Recommendation Report for Planning Permission for Works or Extension to a Dwelling

REF NO: P/131/20/HH

LOCATION: 27 Swandene
Pagham
PO21 4UP

PROPOSAL: Small front and rear extension together with conversion of part of the garage to to accommodate, bedroom, wet room, and utility space maintaining access to rear garden area.

Proposed Plans

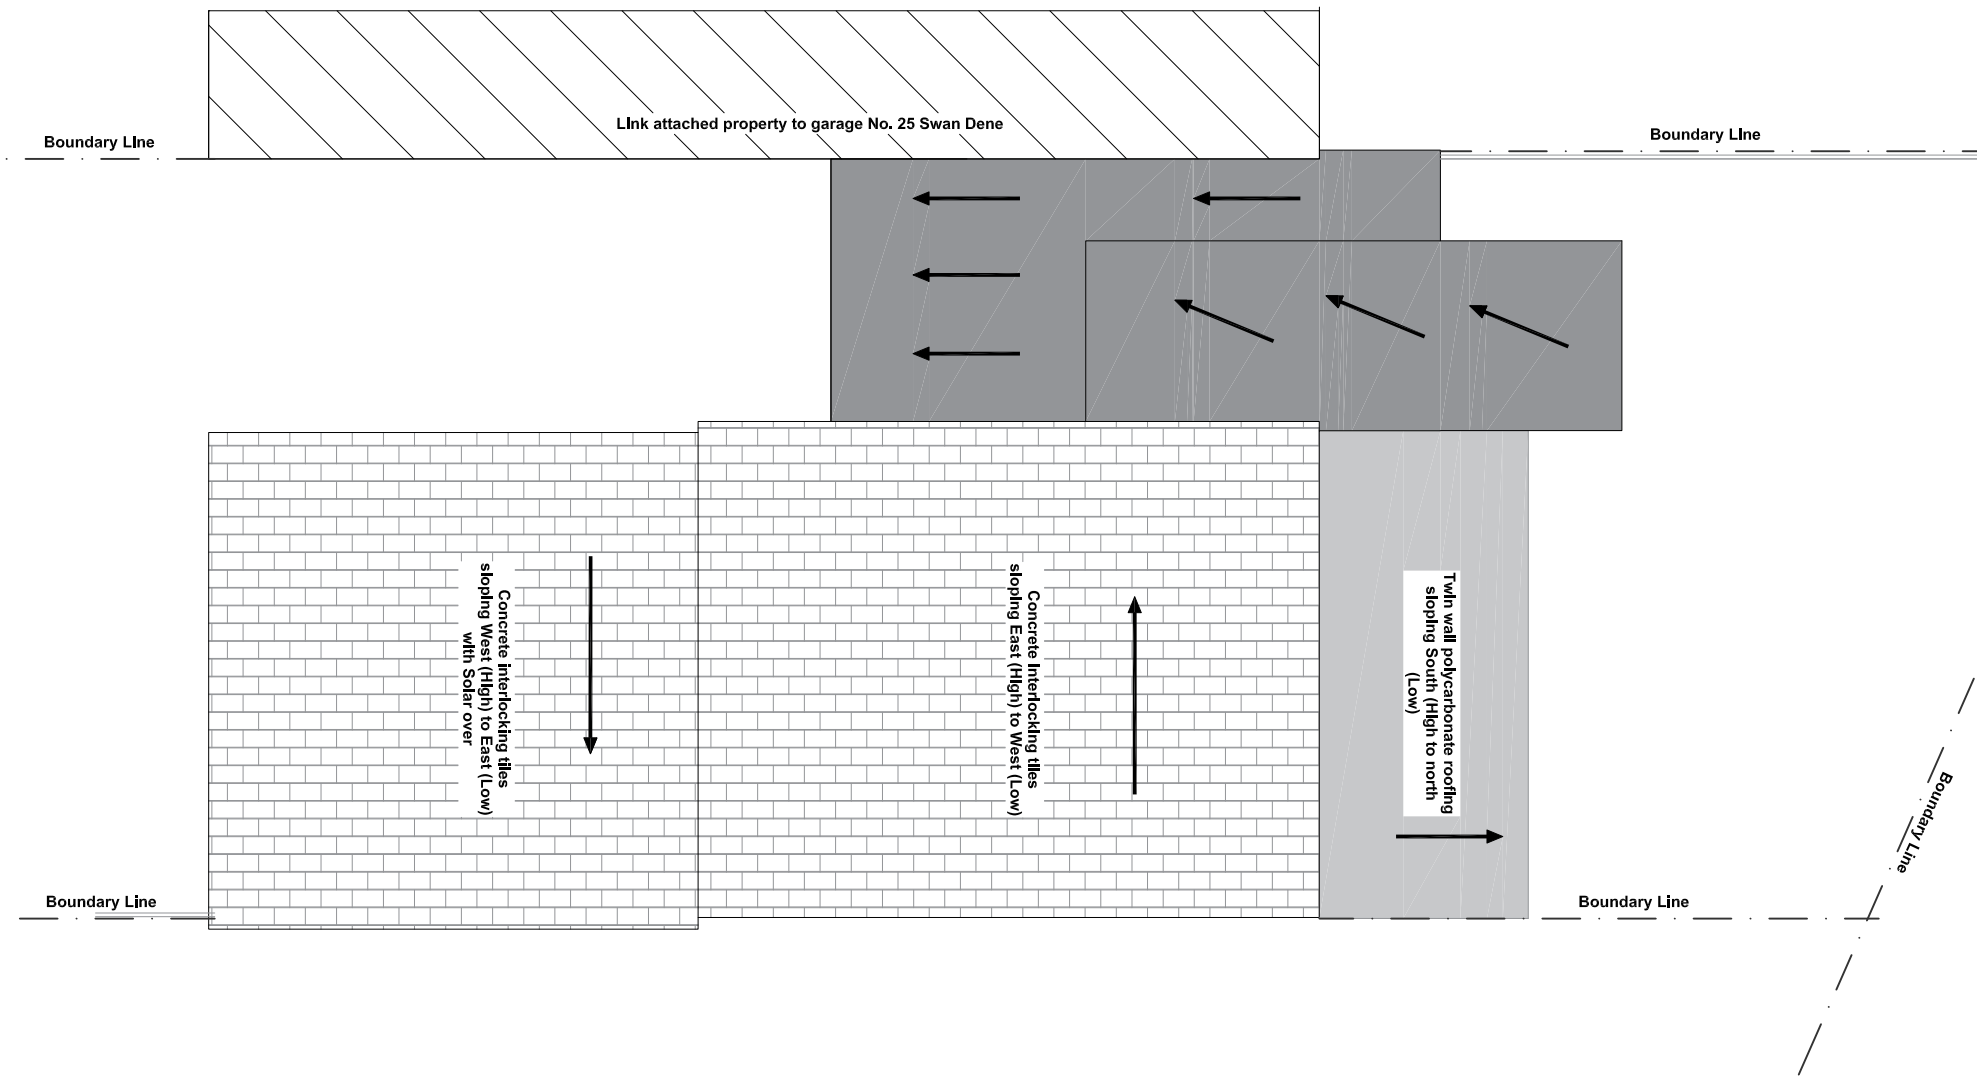
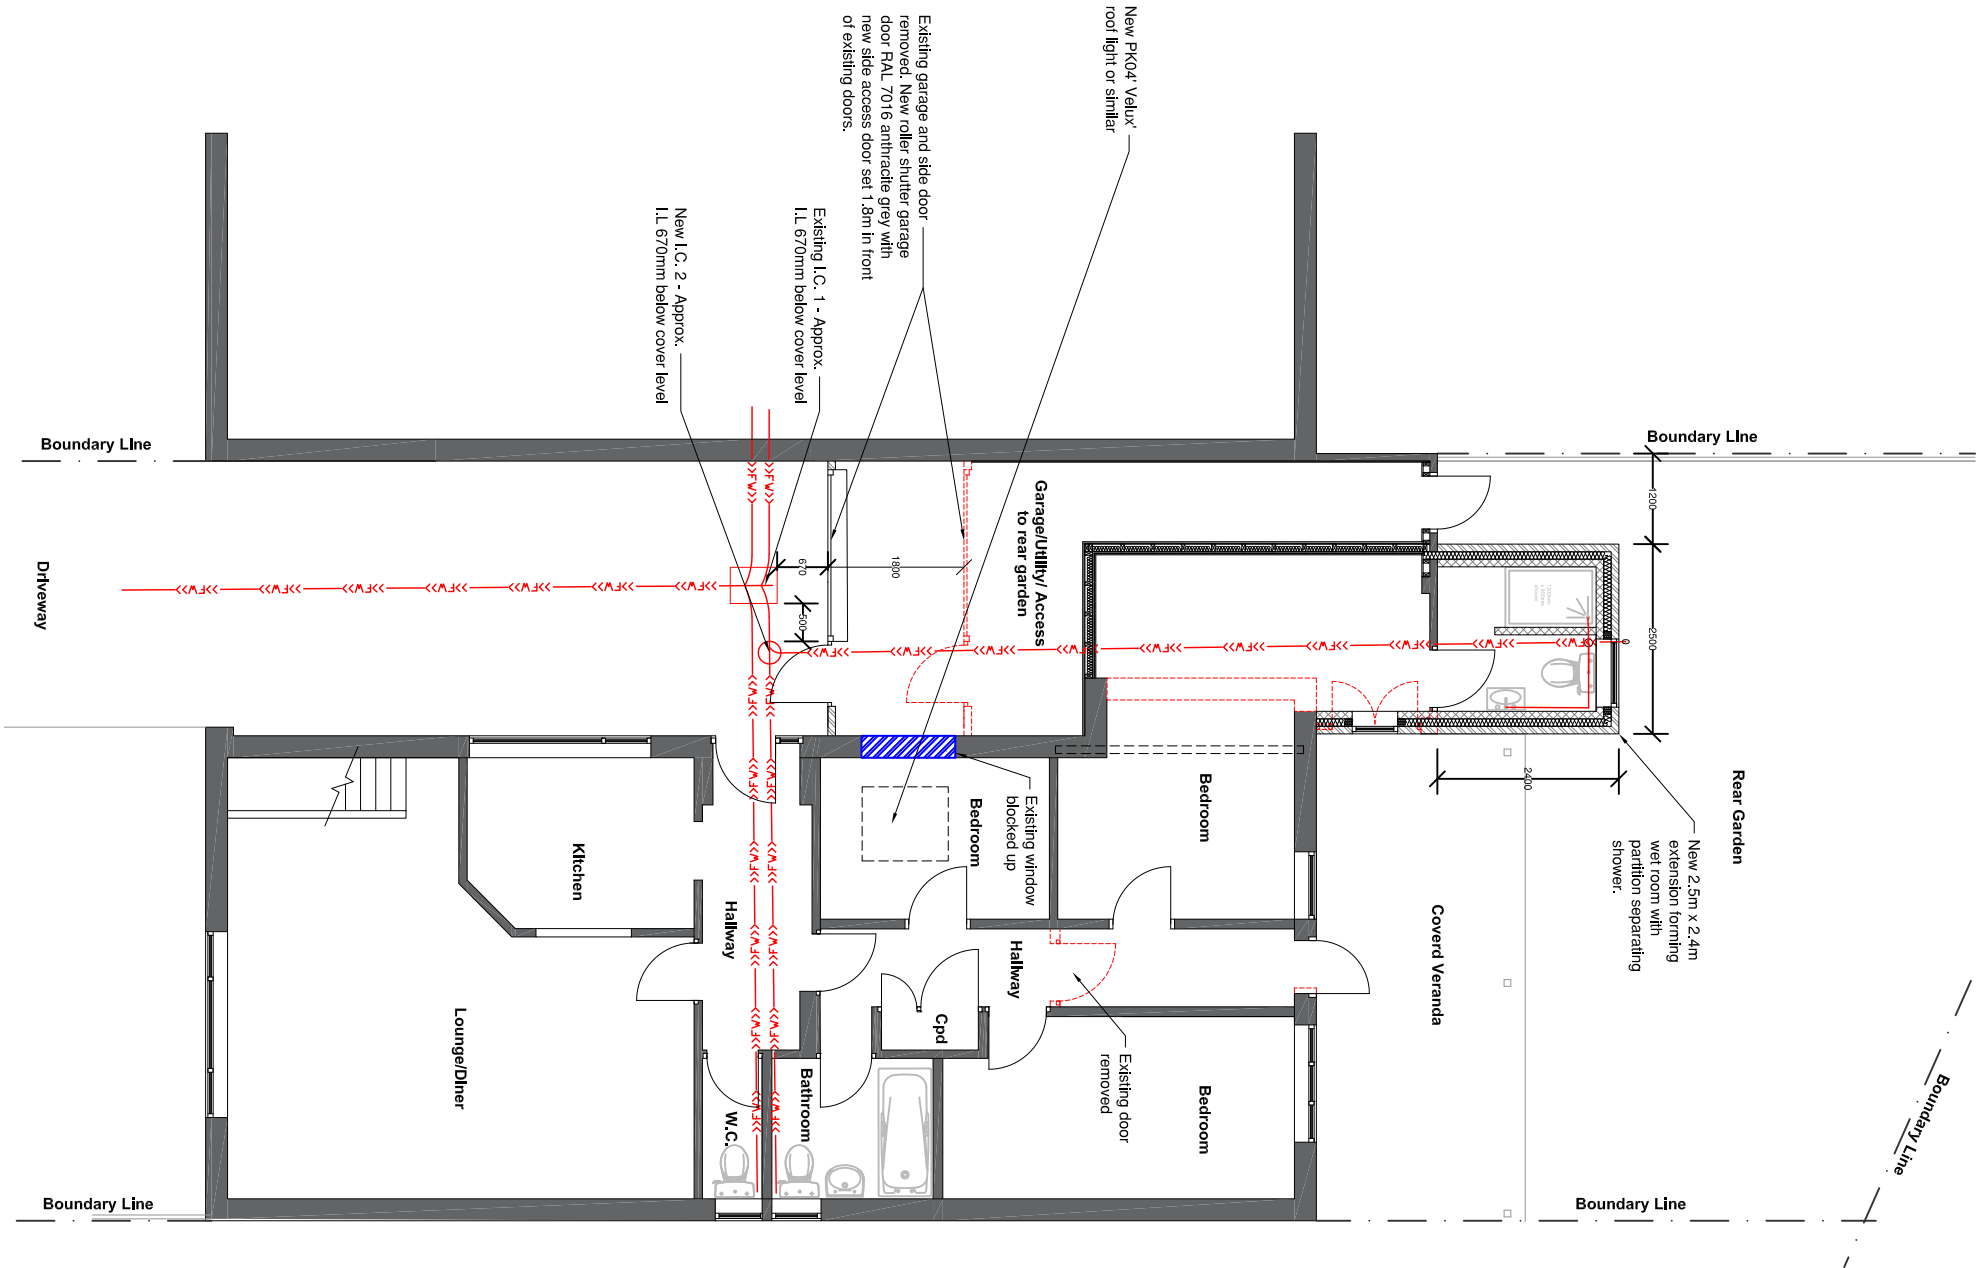
DESCRIPTION OF APPLICATION Front and rear single storey extensions. Front infill extension projecting 1.8m forwards of the existing garage frontage. Rear extension measures 2.4m in depth and 2.5m in width.

The extensions are to be flat roofed and constructed with materials currently found on the host dwelling. The front extension will spring off the Southern elevation, maintaining its alignment with the existing garage, yet be positioned well back from the forward building line. It will have similar design features, consisting of a roller garage door and pedestrian entrance door, as such is considered to subservient to the host dwelling.

The rear extension is to provide an appropriately sized wet room. It is to be built in materials which match existing and consist of fenestration which is of similar appearance and scale to the host dwelling.

In order to provide adequate internal height to the wet room extension an increase in the overall height of the existing central flat roofed section by approximately 300mm has been proposed. The section covering the garage and covered passage towards the rear of the property, the section which runs along the shared boundary with No.25, is to remain the same. At its highest point the new central flat roof section is 1.2. from the boundary with No. 25. and as such the increase in height is not considered to be detrimental to neighbouring properties.

DRAWING TITLE:
Proposed Elevations

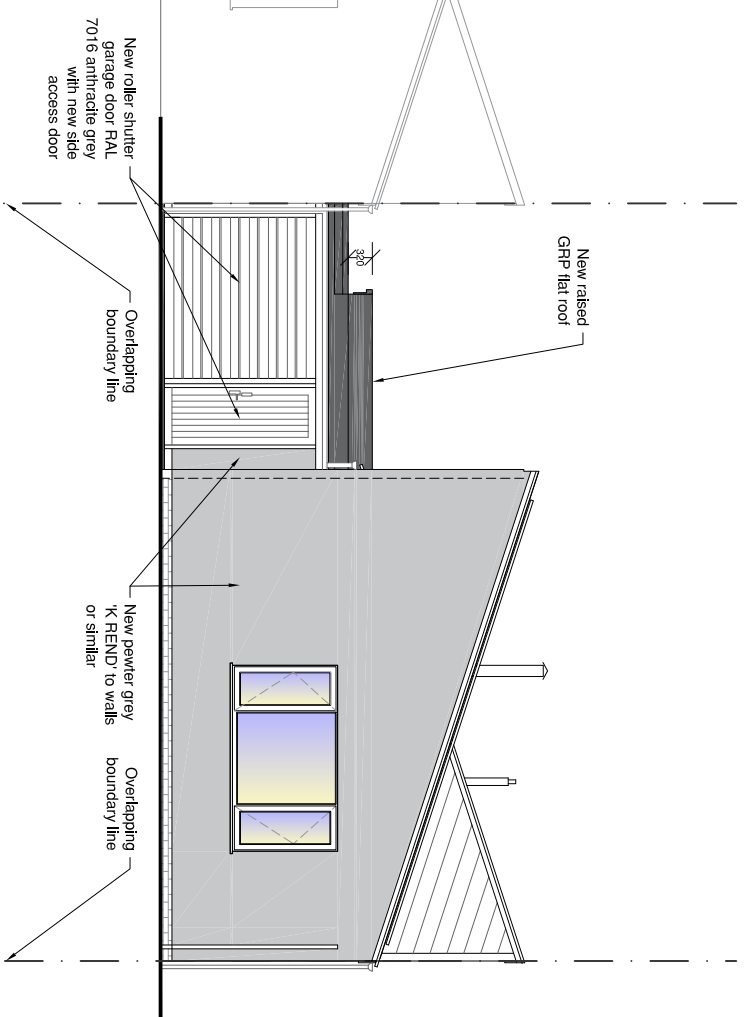
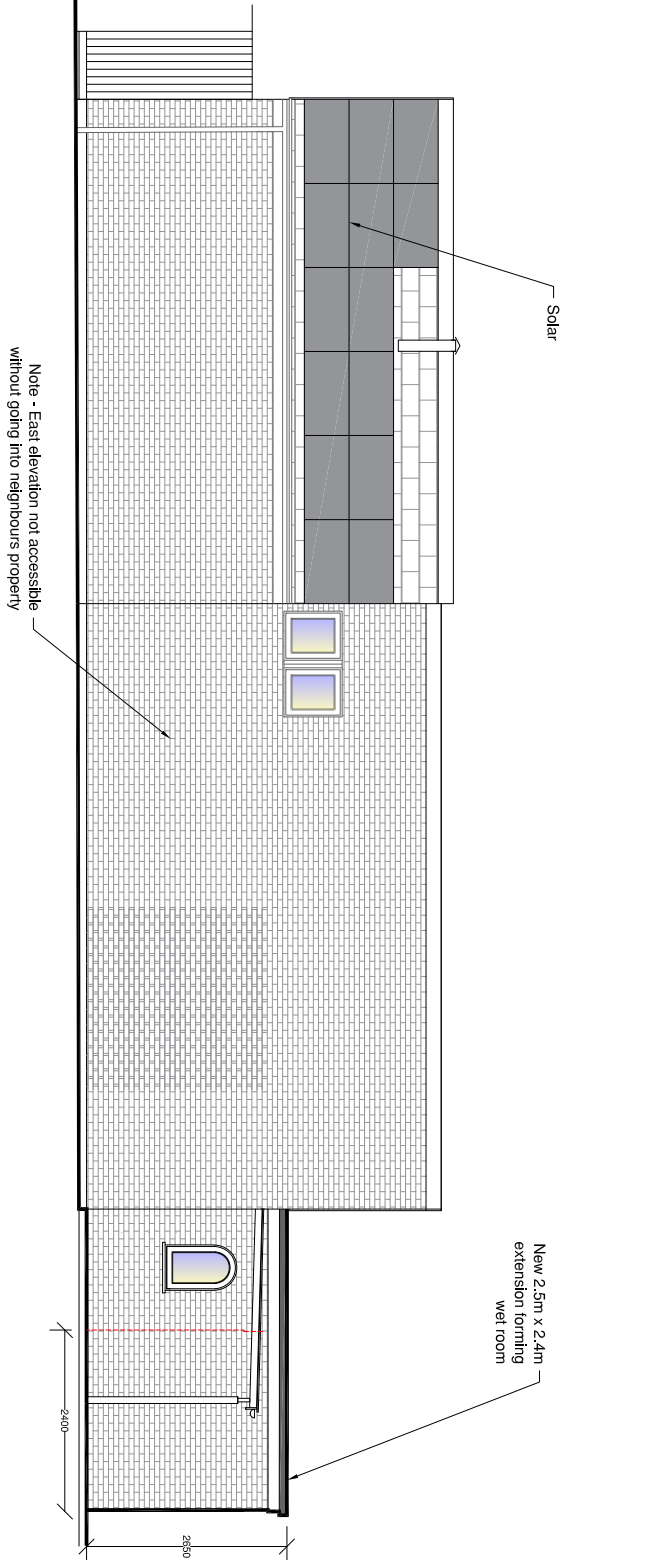
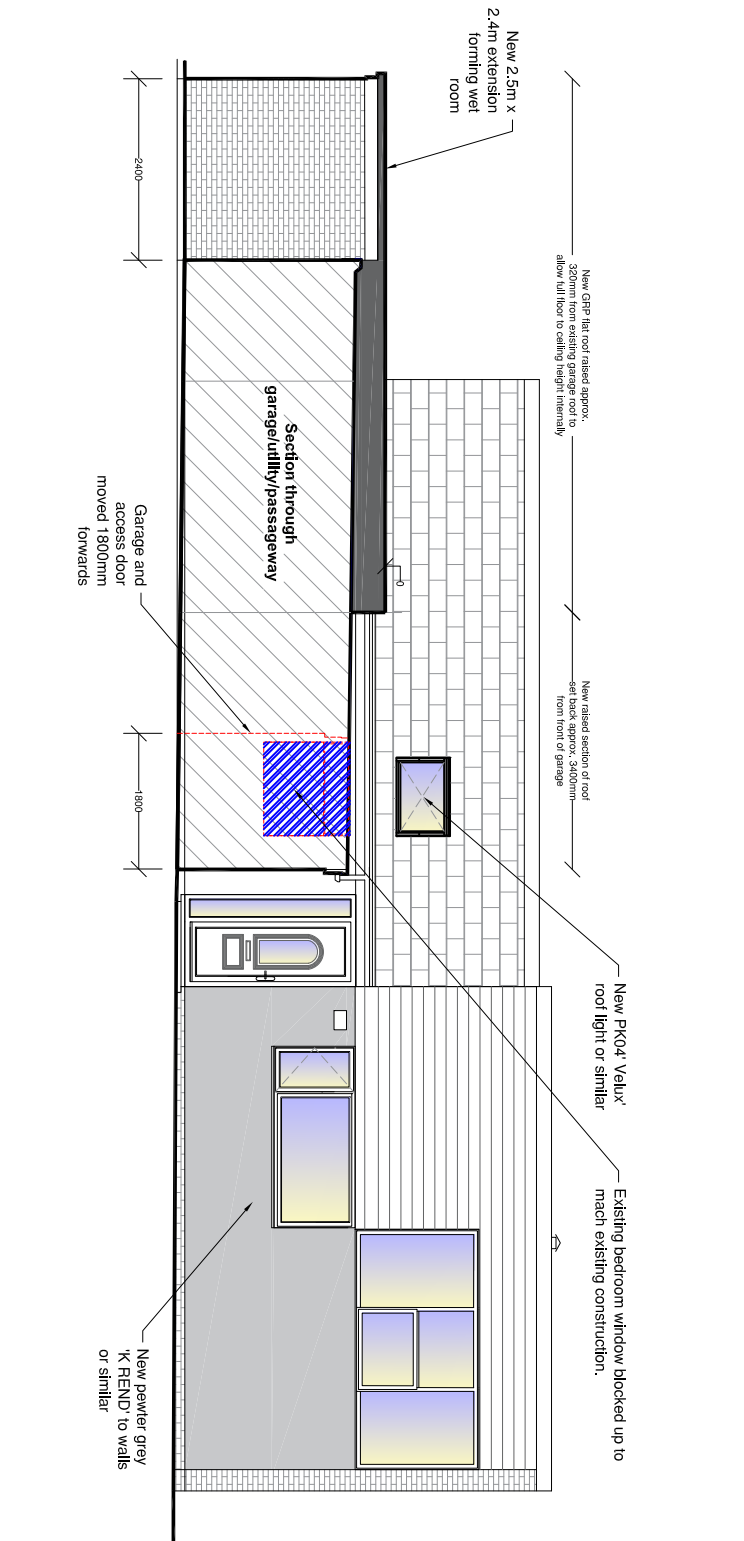
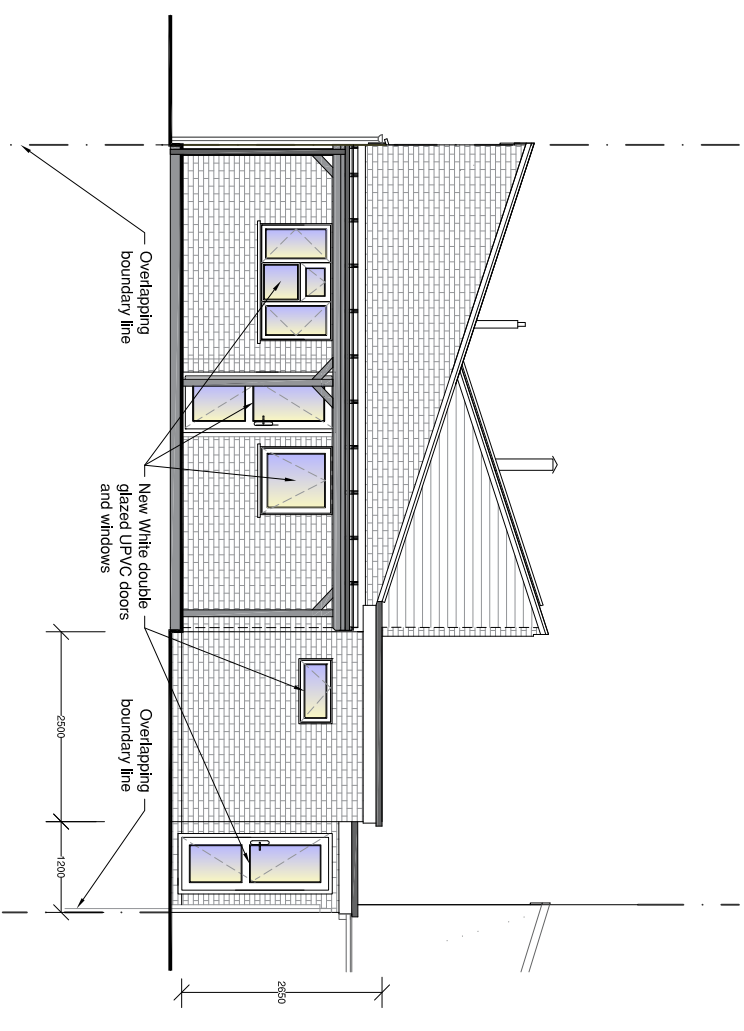
As the front extension has similar design features to those which currently exist, and the alignment of the wall is to match the existing it is considered that there will be little effect on the street scene. It is thought that the scale and style of the extension is harmonious with the location. A change in external finish to the front of the building is proposed. Currently the Western elevation consists of render with weatherboard cladding, it is proposed to render this elevation; the front south facing elevation currently consists of faced brickwork and again, a rendered finish is proposed.

Although the Western external appearance changes are seen in a positive light the changes to the Southern elevation will appear slightly incongruous in this location; there is a uniformity and a unique style to the building facades which by rendering will be lost. Notwithstanding this point, it does not warrant refusal of this application and the proposed extension by reason of its scale and style accords with policies DDM1 and DDM4 of the Arun Local Plan
